February 13, 2024

RE: Ridge at Lorson Ranch Filing No.  
Certification Letter

POND C2.1 IS LOCATED IN TRACT G, THE HILLS AT LORSON RANCH FILING NO. 1. SEE MAINTENANCE AGREEMENT AT REC. NO. 220211669

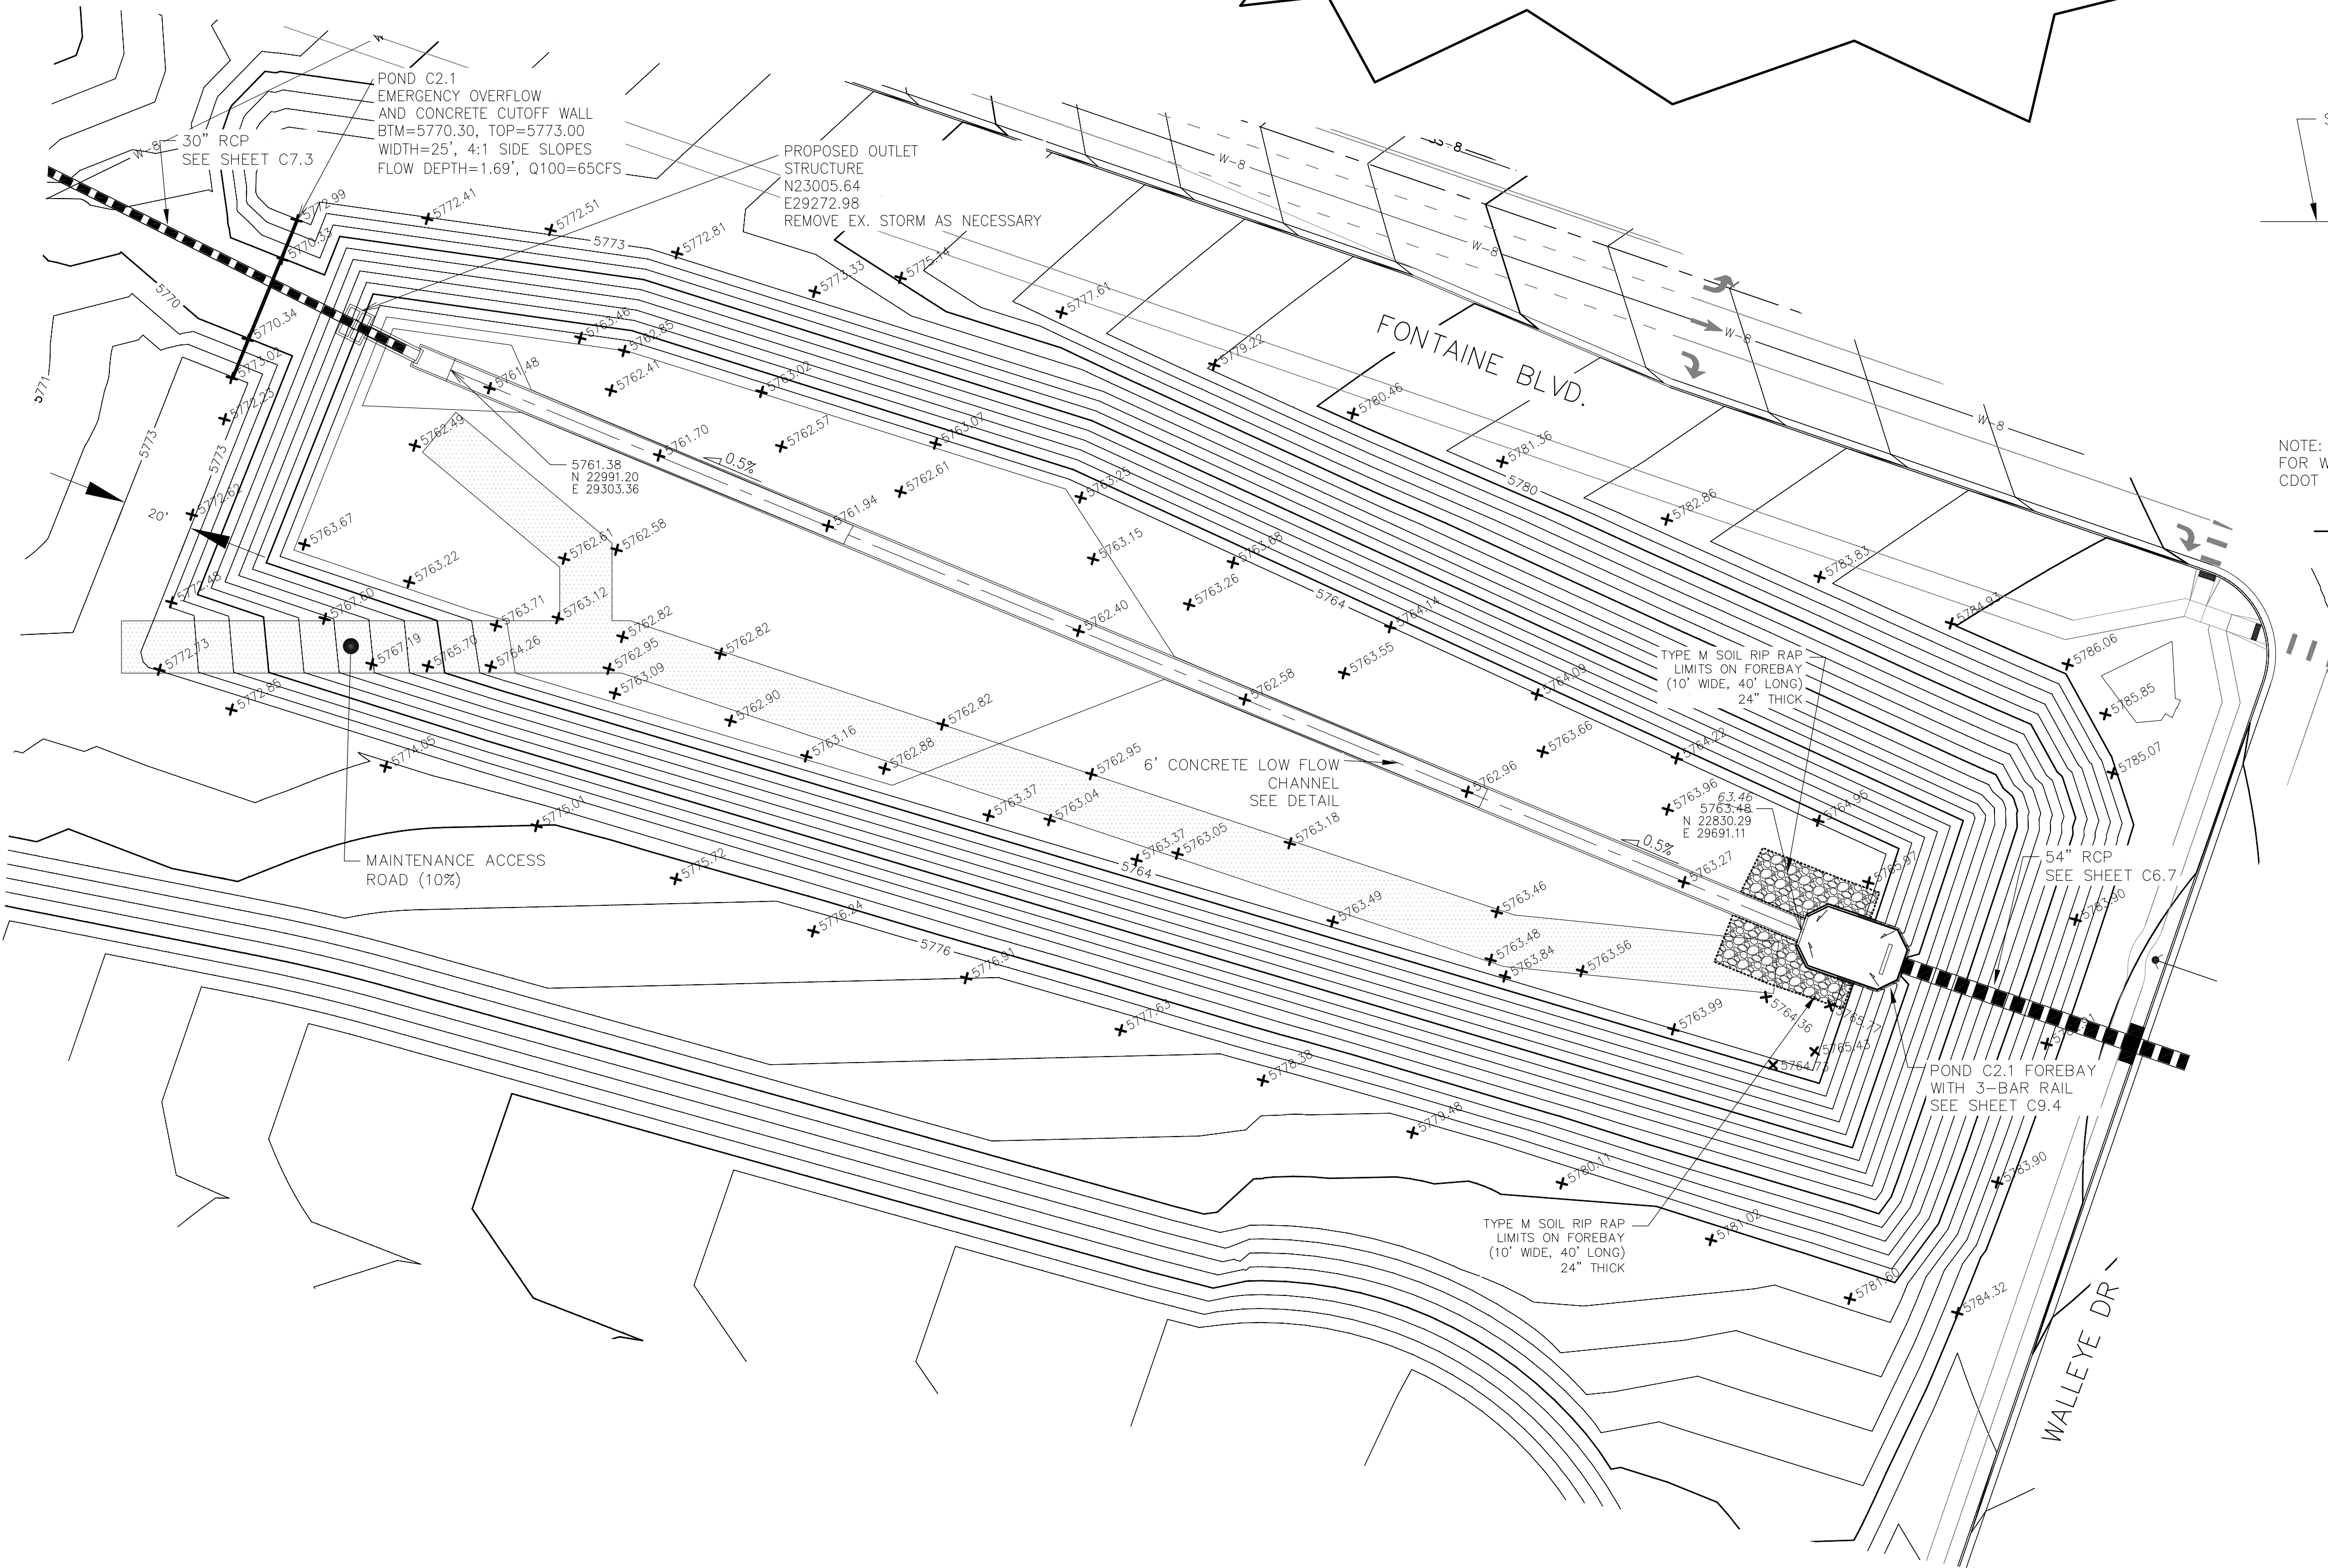
This letter was for the as-builts for SF2110 & CDR207, which was only the partial/interim condition of Pond C2.1. And then SF224 included the ultimate condition of the pond. So please clarify that here.

Remember that if the as-built conditions include any significant changes to the ponds, you will need to submit revised MHFD-Detention calcs that reflect the differences.
